**Consultation Response from Mike Hibbert,
KC Waste Strategy(Refuse & Recycling)**

2024/93077 Dunkirk Inn, 231, Barnsley Road, Lower Denby, Huddersfield, HD8 8TX

Discharge details reserved by conditions 15 (waste/recycling facilities), 16 (charging electric vehicles), 17 (landscaping), 18 (residential amenity) on previous permission 2020/91601 for change of use from agricultural land to Sui generis Drinking Establishment (previously A4) and erection of extensions and alterations

Date Responded:18/12/2024.

Drawing DC02
 External Landscaping Works and Residential
 Amenity Protection Measures
 at
 The Dunkirk Inn, 231 Barnsley Road, HD8 8TX

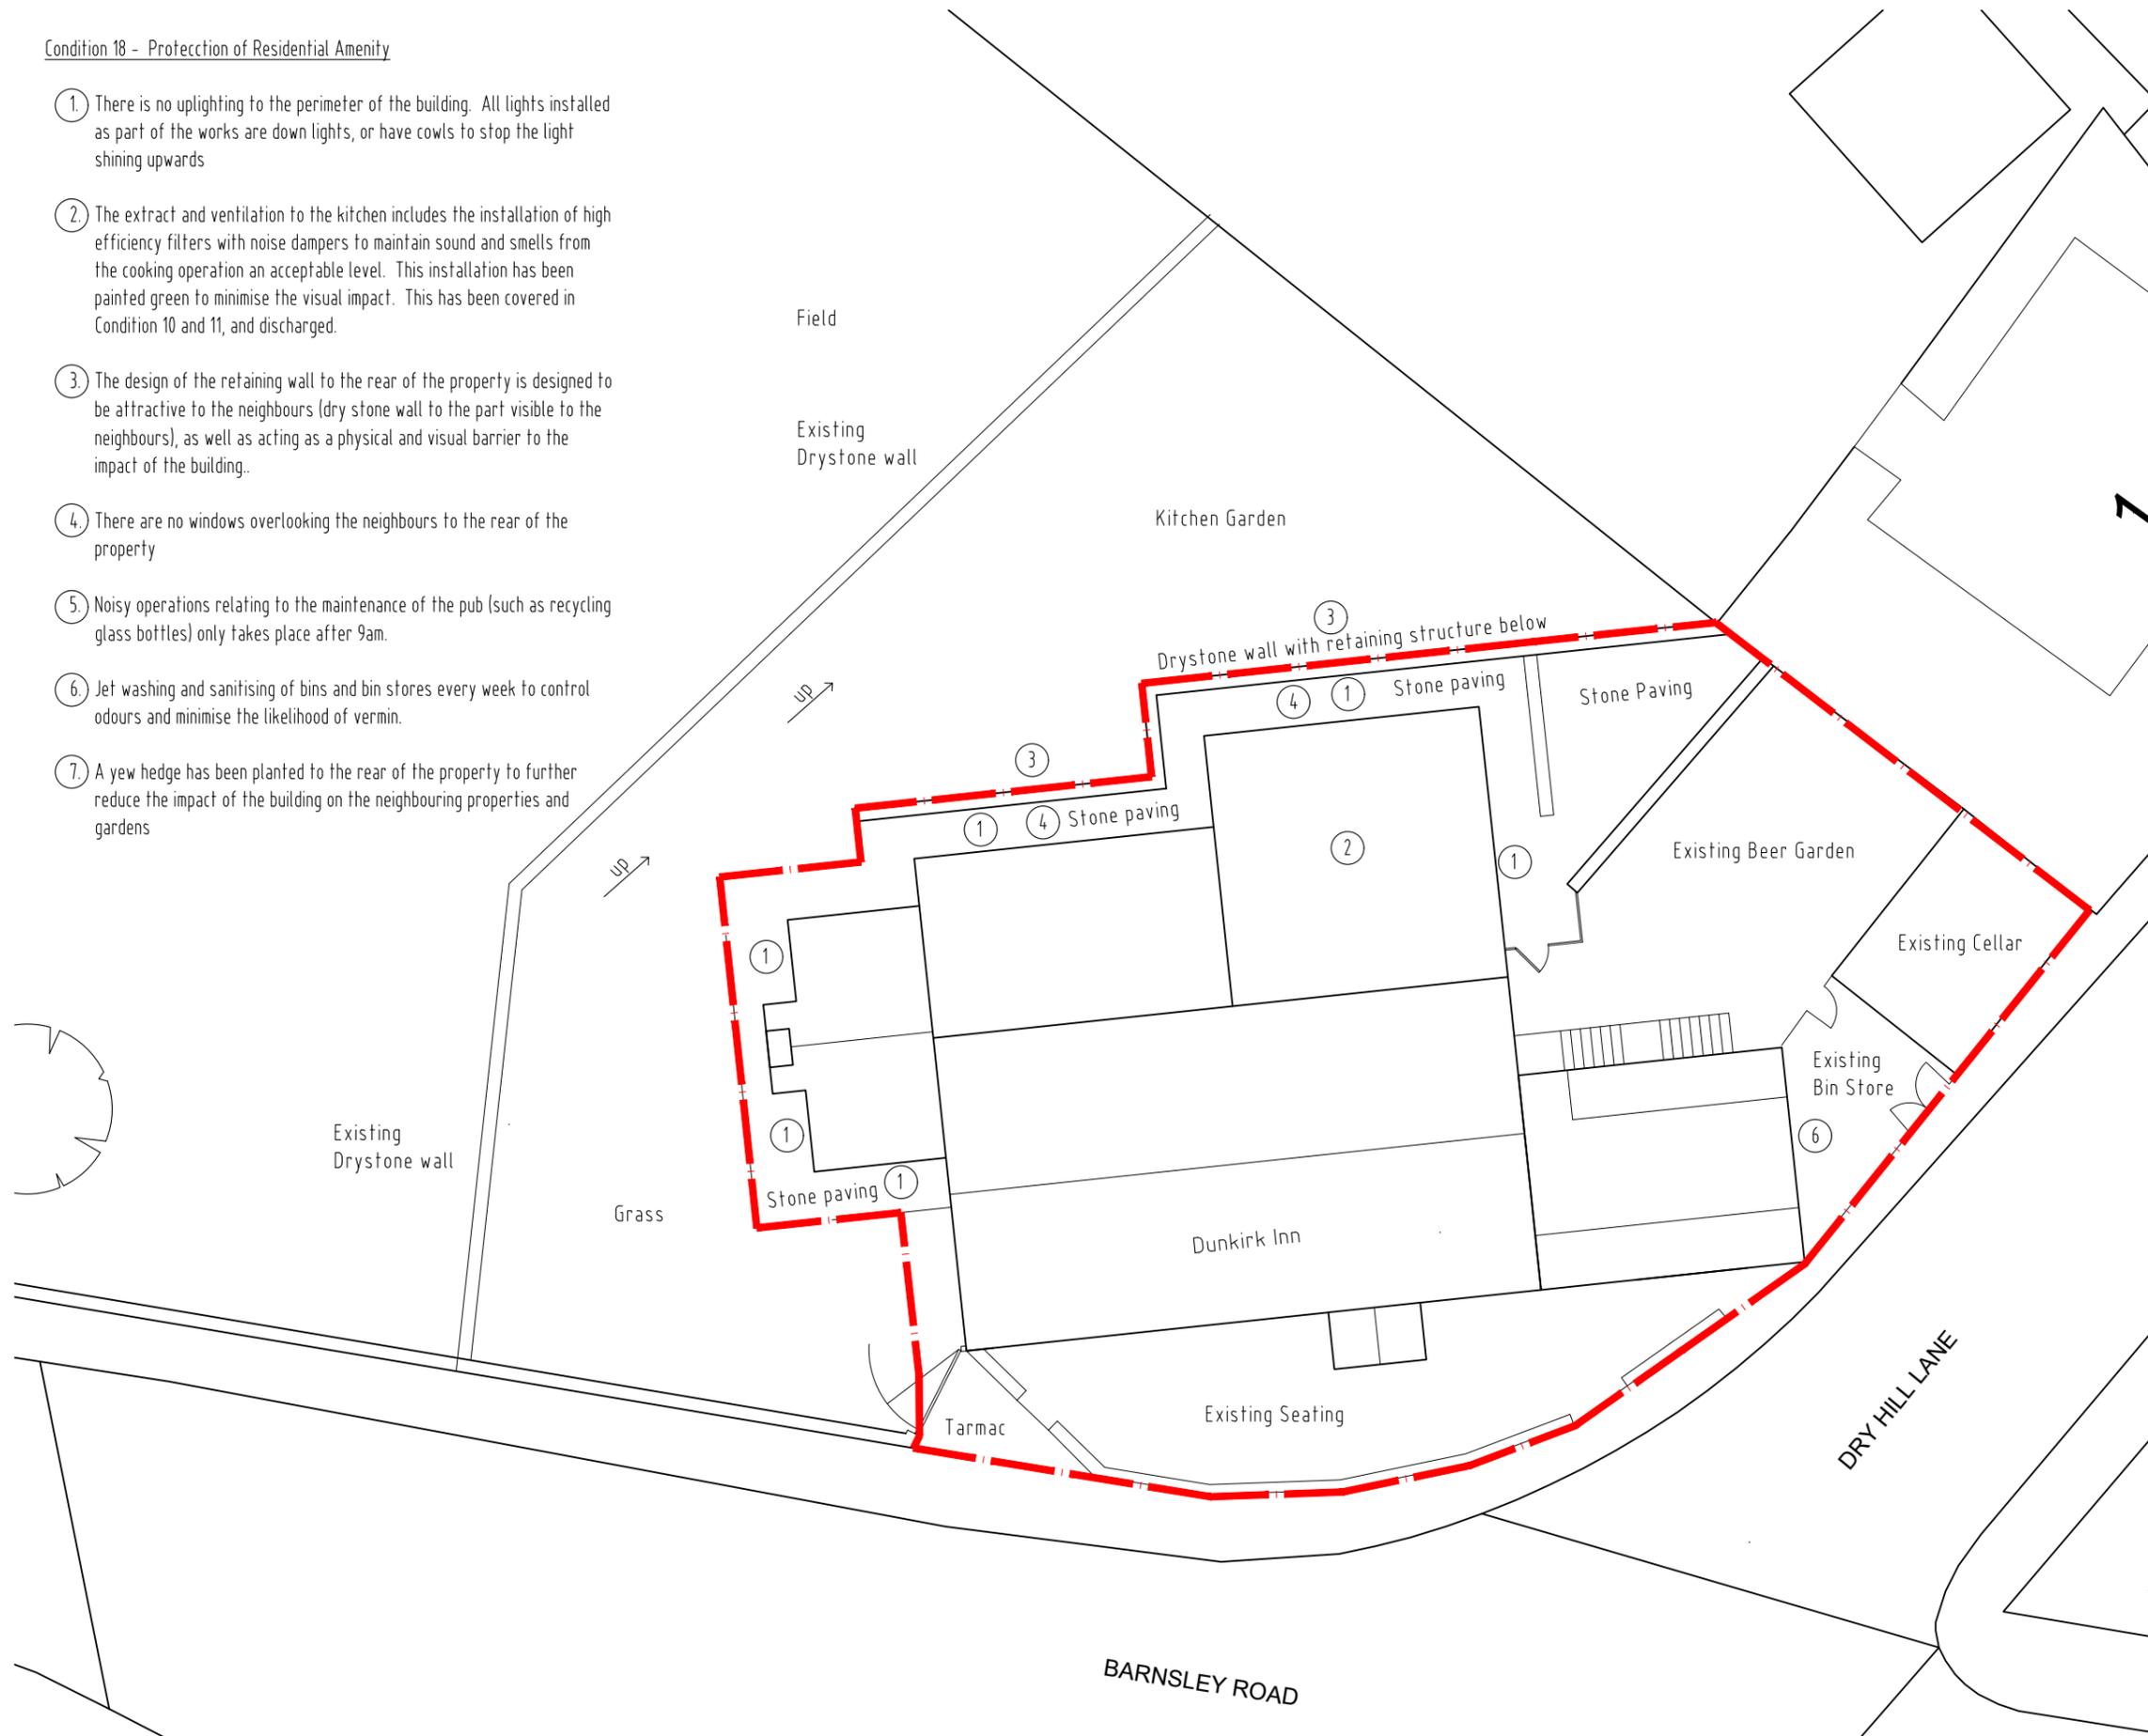
Plan DC02 shows the waste storage area for general wastes adjacent to the public house

The Waste Collection Authority can confirm that the proposals are acceptable and that Condition 15 can be discharged.

Drawing DC01  
Electrical Vehicle Charging and Recycling Facilities  
at  
The Dunkirk Inn, 231 Barnsley Road, HD8 8TX

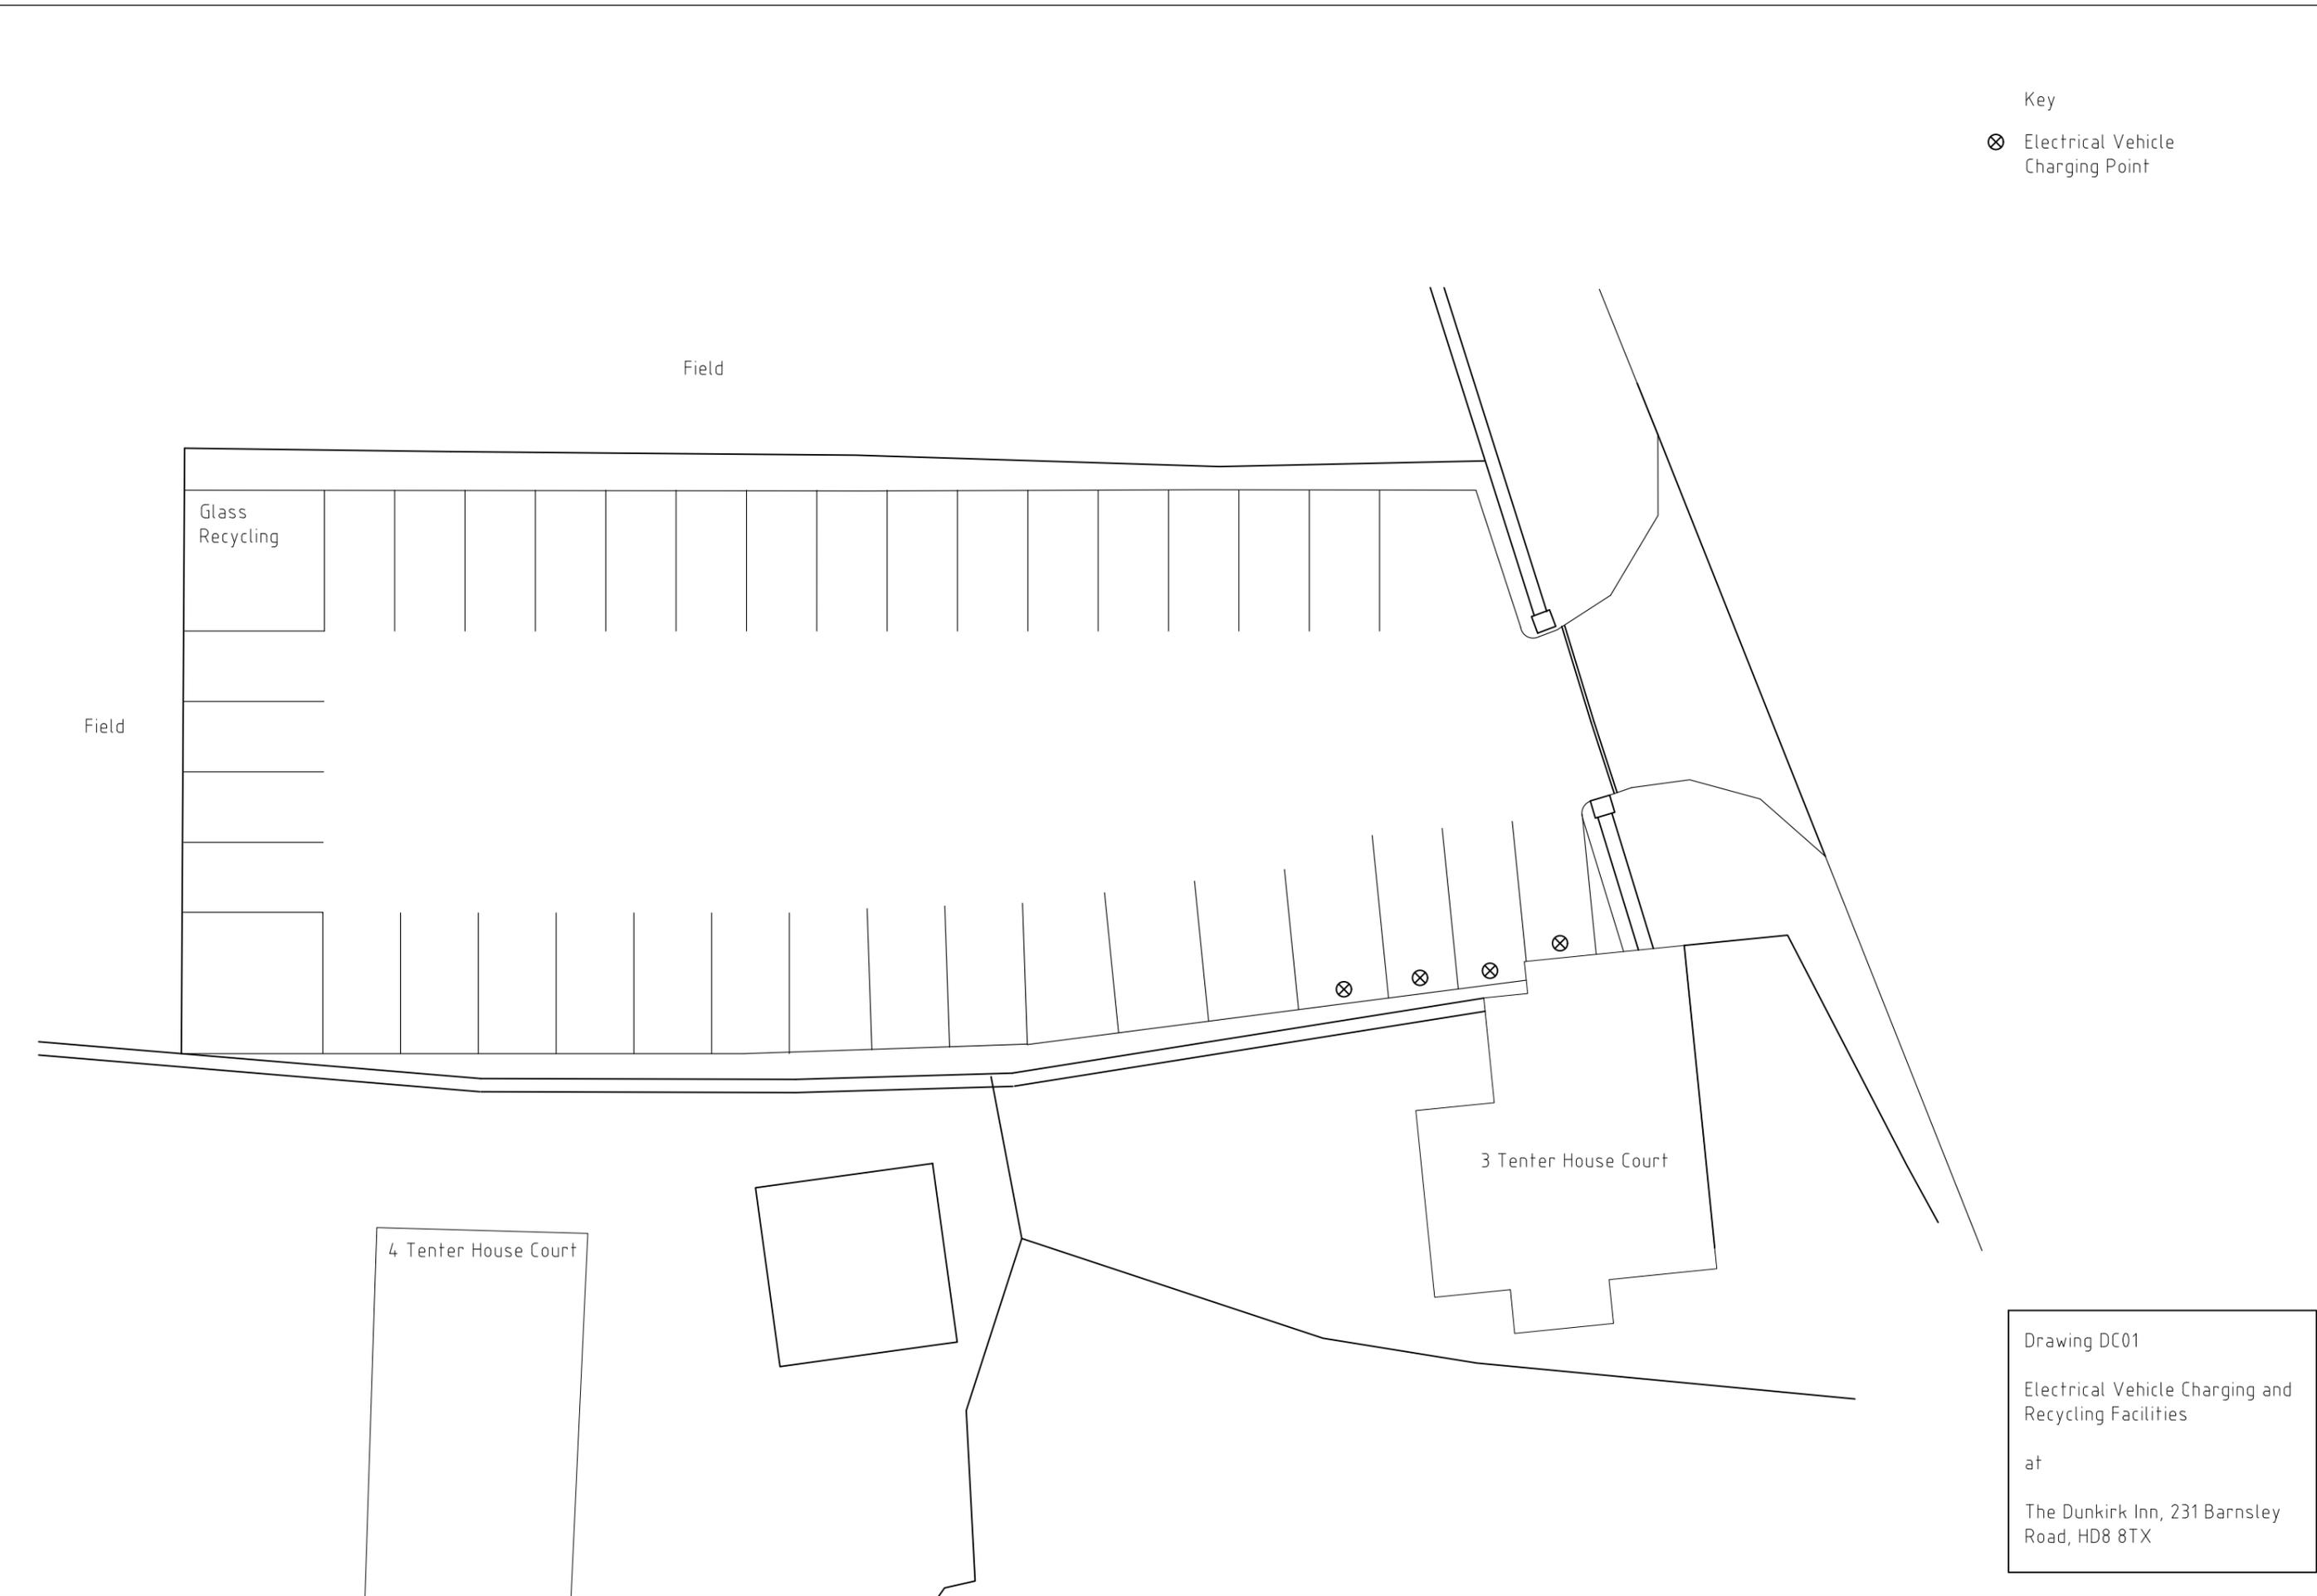
The application also includes Plan DC01 that shows the location of the Glass bank on the carpark
